**ADC Planning Consultation
Response from the Conservation Officer**

Application Number	BR/322/13
Address	Swansea House, West Street, Bognor Regis
Description	Replacement windows
Case Officer	Mr. Simon Davis

The proposal is for replacement windows in the southern elevation to the property. The property is a flat, and therefore does not enjoy its permitted development rights.

South Elevation.
(Remains Unaltered)
(1:100)

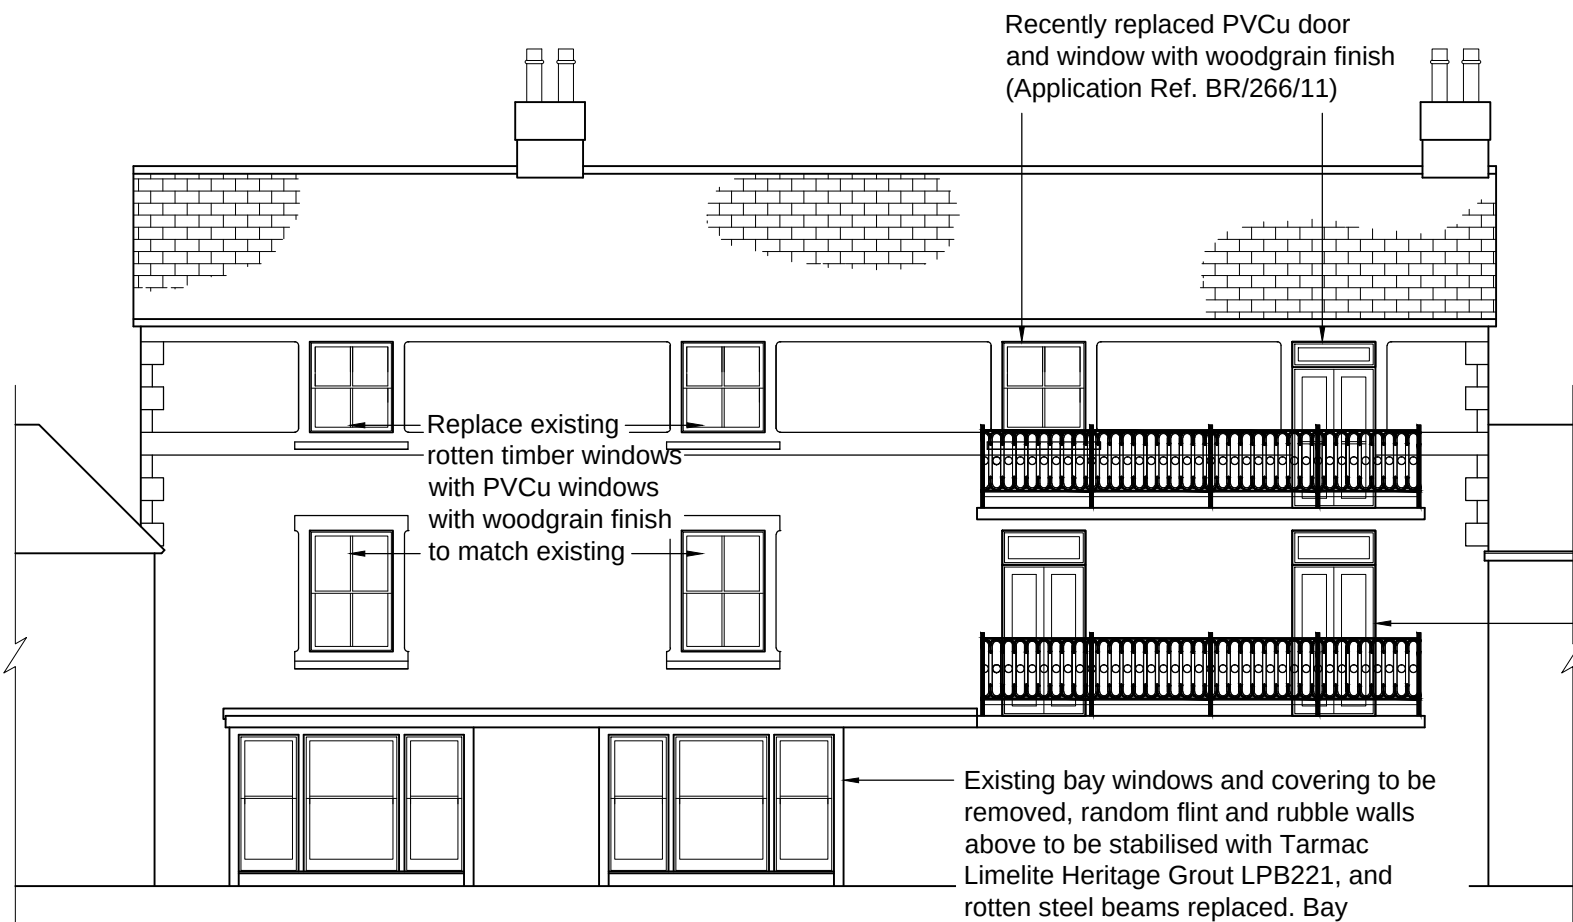
The visual impact of uPVC replacement windows is out of keeping with the design and character of historic buildings and conservation areas and it is generally inappropriate to use them. The thickness of frames and glazing bar cannot be accurately reproduced in alternative materials such as uPVC. As the thickness of such elements of a window are critical to its appearance when viewed from the street, timber is preferred and the most realistic option. It can easily compete with uPVC in terms of longevity, if well cared for.

1. uPVC windows generally include visible black rubber glazing gaskets, these have a significantly different appearance to painted putty or timber beading;
2. applied details do not adequately replicate the integrity of decorative carved timber detailing;
3. the finish of uPVC windows has a synthetic appearance that does not adequately replicate a painted finish on wood, even when a grain finish is specified; and
4. glazing bars are usually stuck on rather than functional and as such have a different appearance.

For these reasons, the application cannot be supported.
